PR 234 Schubert Ranch Sand Resource

1/30/2024

Grading and Erosion Control Plan Checklist, Response to Comments:

STAGE 1 OF 6 - GRADING AND EROSION CONTROL PLANS

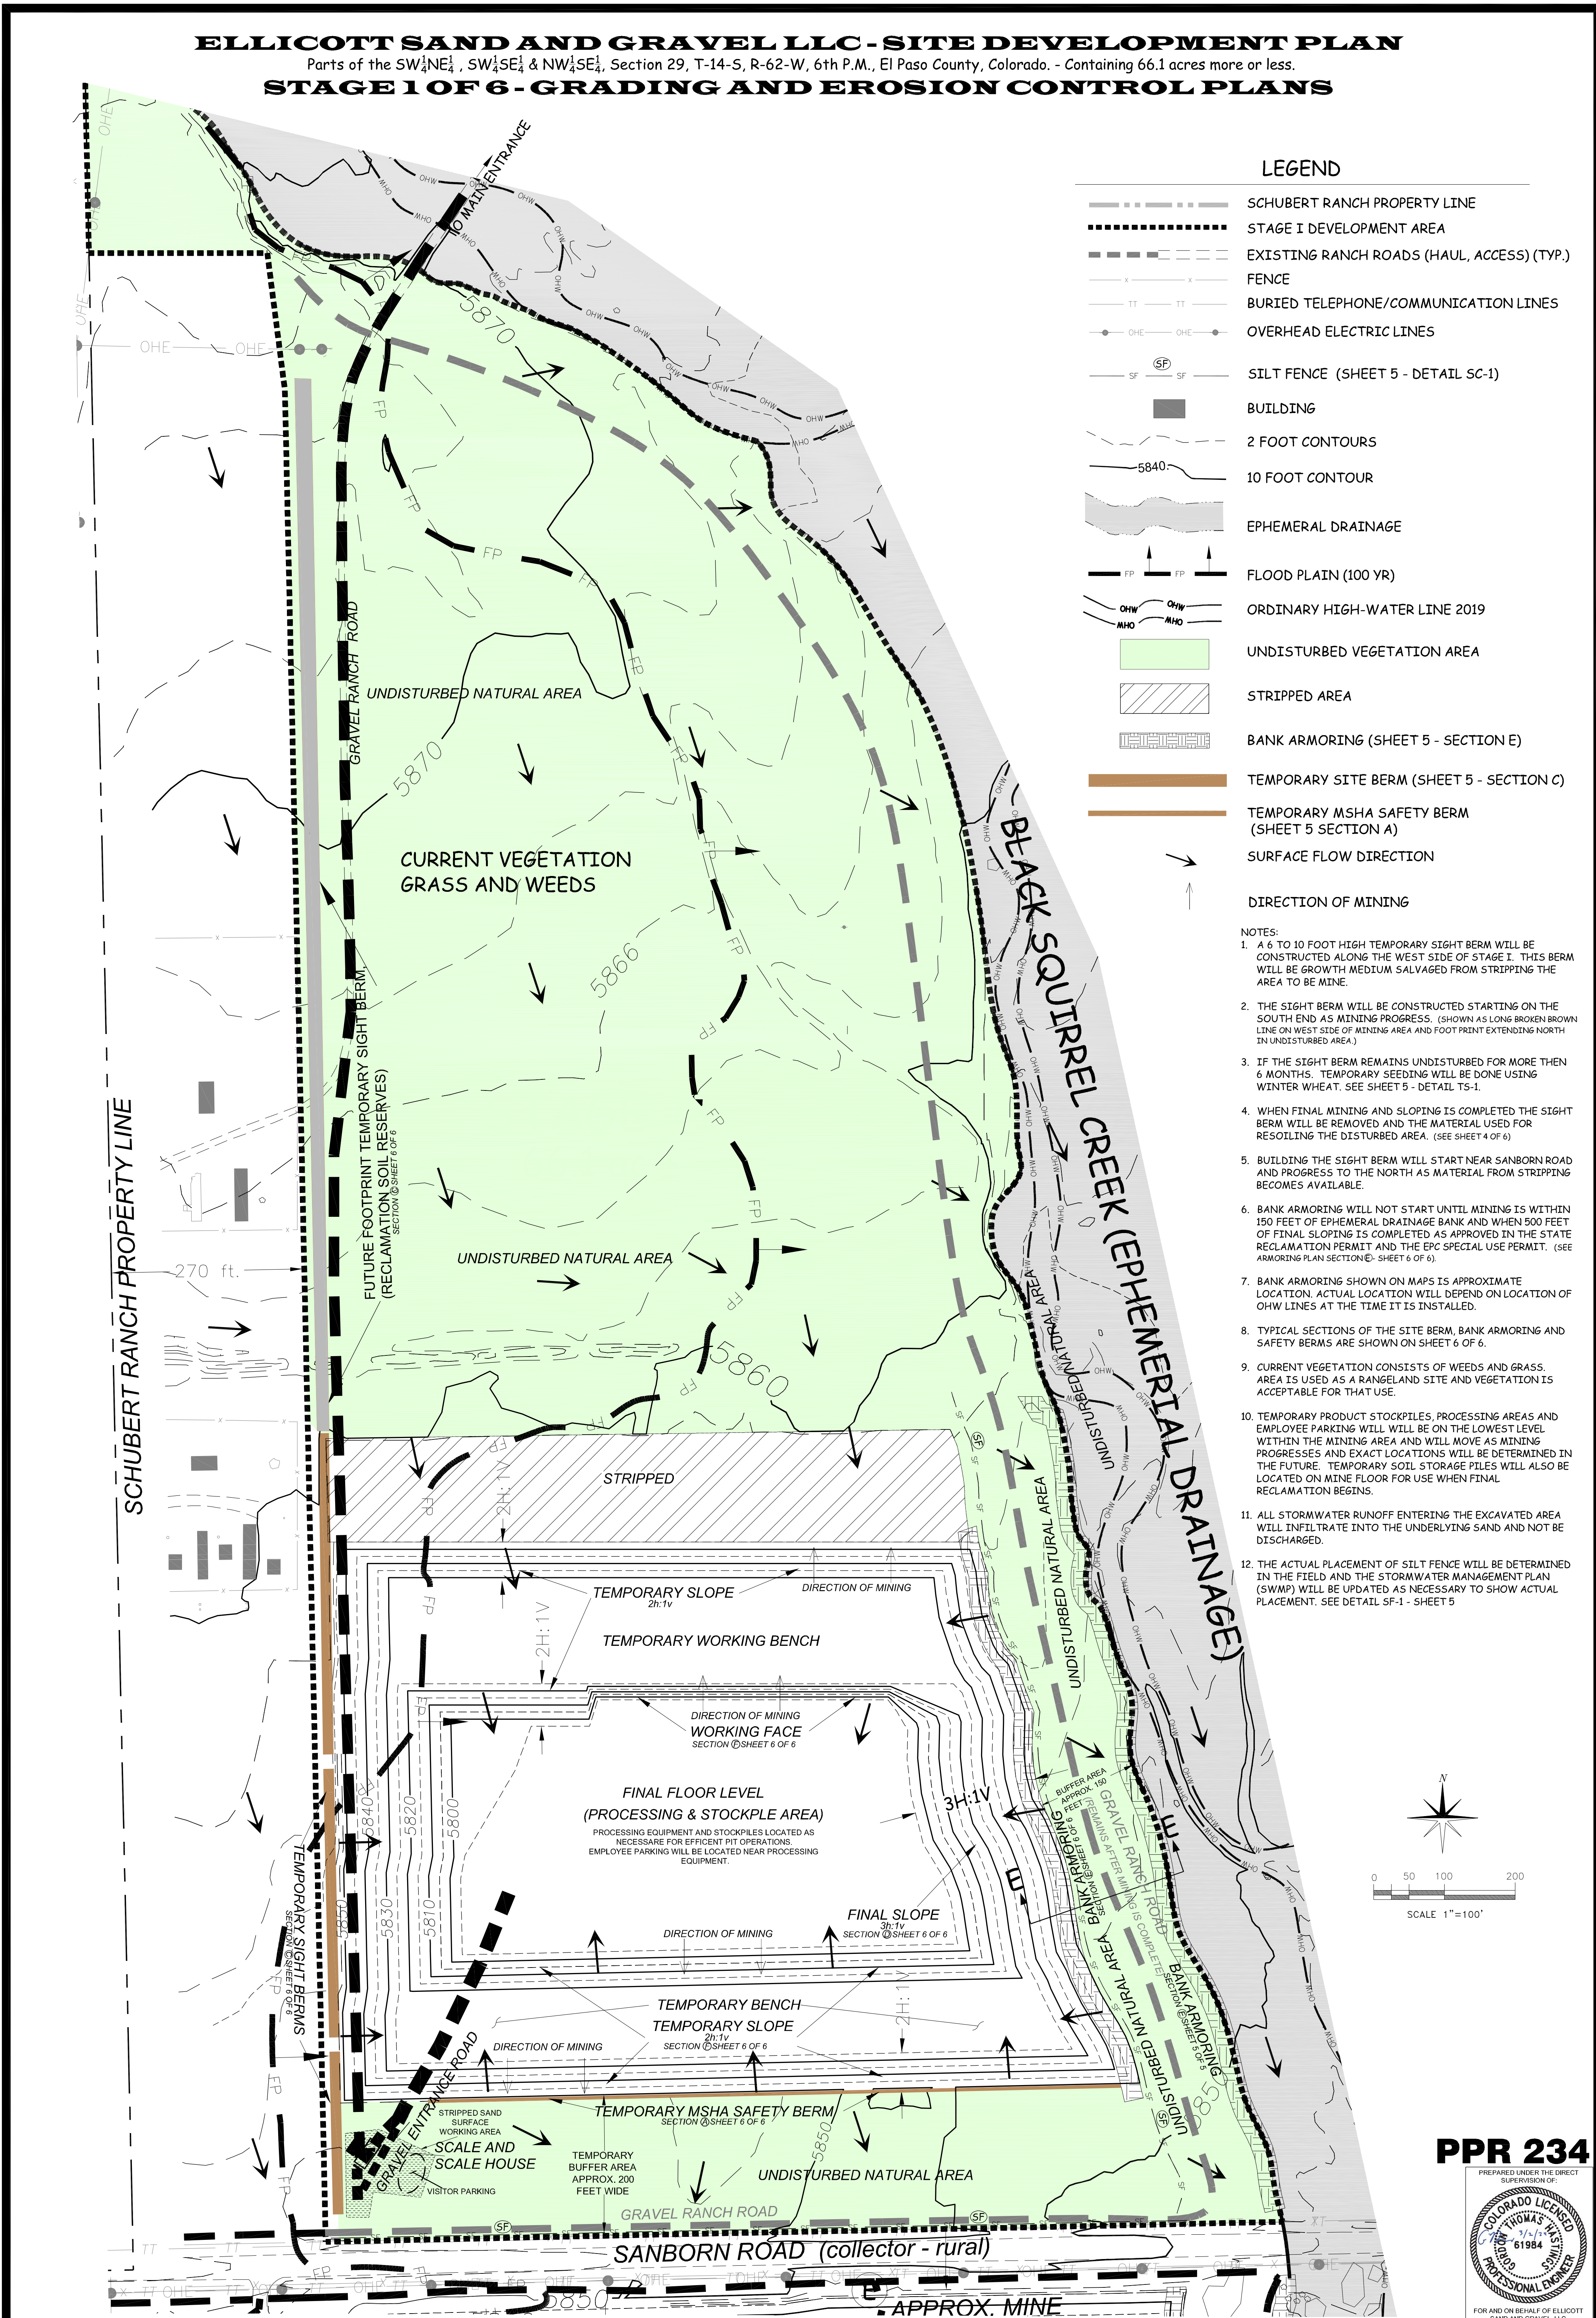
1. PPR 234 has been added to all pages.
2. Applicant column has been completed.
- z. We do not plan or anticipate the need for temporary construction control measures.
- cc. There are no existing or proposed easements. There are no affected off-site easements of which we are aware.
- dd. No retaining walls are planned.
2. a-k Please see checklist.
- 3.28 The requested information has been placed on Sheet 1, GEC Plan.
